<b>Application Ref:</b>	3/2025/0811			 Ribble Valley Borough Council <a href="http://www.ribblevalley.gov.uk">www.ribblevalley.gov.uk</a>	
<b>Date Inspected:</b>	24/10/2025	<b>Site Notice:</b>	N/A		
<b>Officer:</b>	MC				
<b>DELEGATED ITEM FILE REPORT:</b>				<b>Decision</b>	<b>PRIOR APPROVAL REFUSED</b>

<b>Development Description:</b>	Prior notification for proposed roof over existing silage clamp 13.72m long, 10m wide, 6.6m high to ridge and 5.2m high to eaves under Part 6 Class A of the GDPO.
<b>Site Address/Location:</b>	Land off Longridge Road, Hurst Green, BB7 9QP

North and south elevations

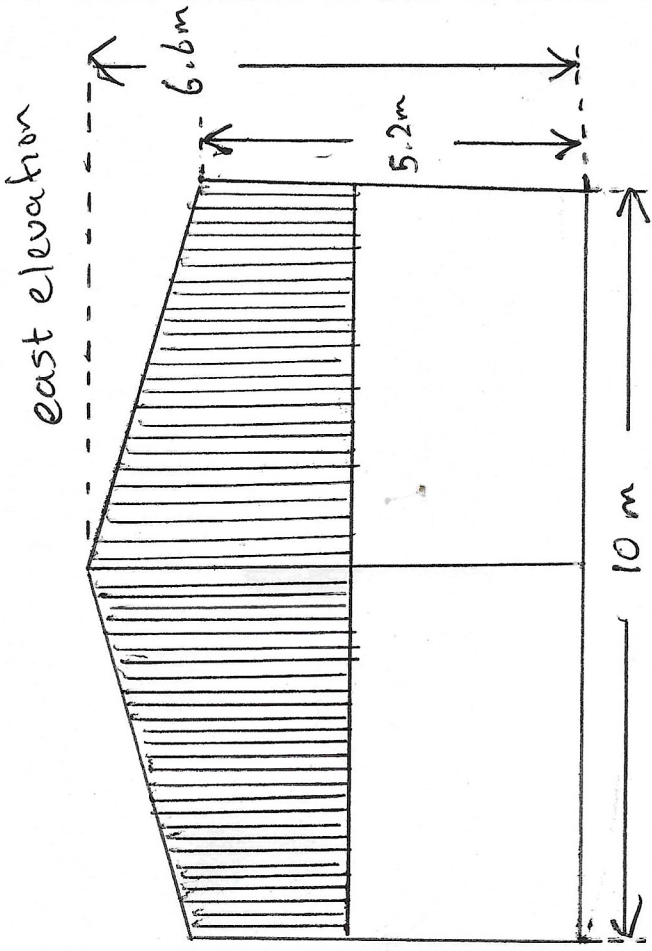
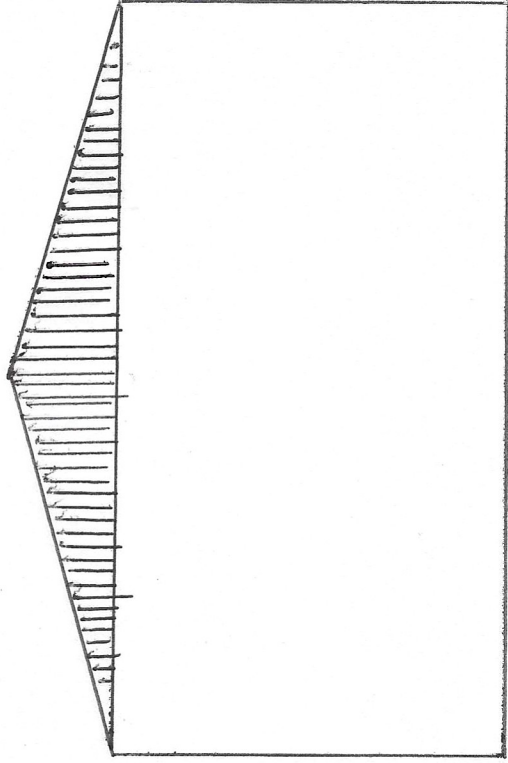
**Design / appearance** – The proposed building is to be constructed using concrete panels, Yorkshire boarding and fibre cement roof sheets in nature grey. The building would have a fairly high eaves height but the ridge height is considered reasonable for an agricultural storage building of this type. In terms of construction, this is typical for an agricultural building of this nature.

**As such Prior approval is not required in terms of design and appearance.**

Existing
BLOCK/SITE PLAN
AREA 90m x 90m
SCALE 1:500 on A4
CENTRE COORDINATES: 367109, 438189

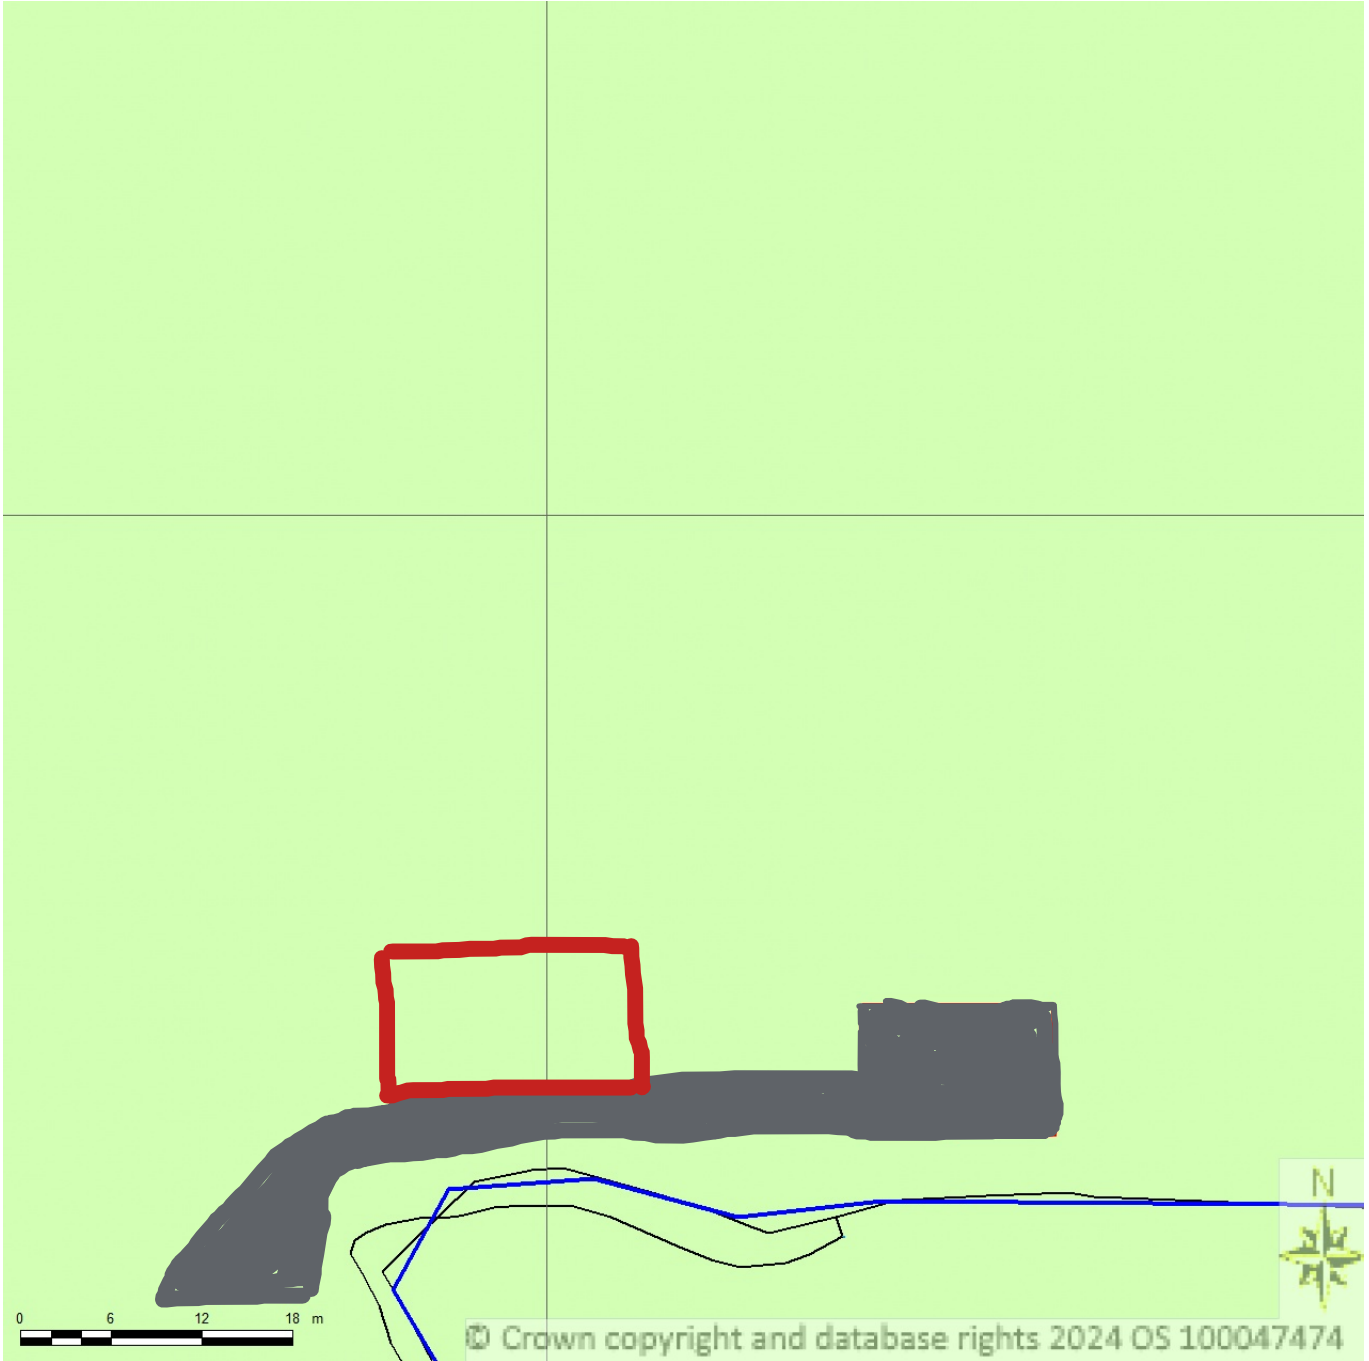
It should be noted that when the Planning Officer visited the site there is no structure currently in situ to add a roof over. Therefore, the proposal is essentially seeking approval for a new building.

In addition, the proposed building does not have an approved access track leading to it. The site also has unauthorised hardstanding and storage containers in situ.

**Siting** – The proposed building is to be located on a parcel of land in an area that is currently void of any structures. There is an existing barn approved at the site and access track, however the additional building would result in a second agricultural building at the site. The existing barn is visible from BW0303005 and it is likely that long range views of the new building will be present from BW0303005 and footpath FP0303003 which is located to the north-east of the site.

Cumulatively the existing agricultural barn, in addition to a new barn for silage storage is considered to result in harm to the landscape character within the Forest of Bowland National Landscape by way of loss of openness and erosion of rural character.

**As such Prior approval is required and refused in terms of siting.**
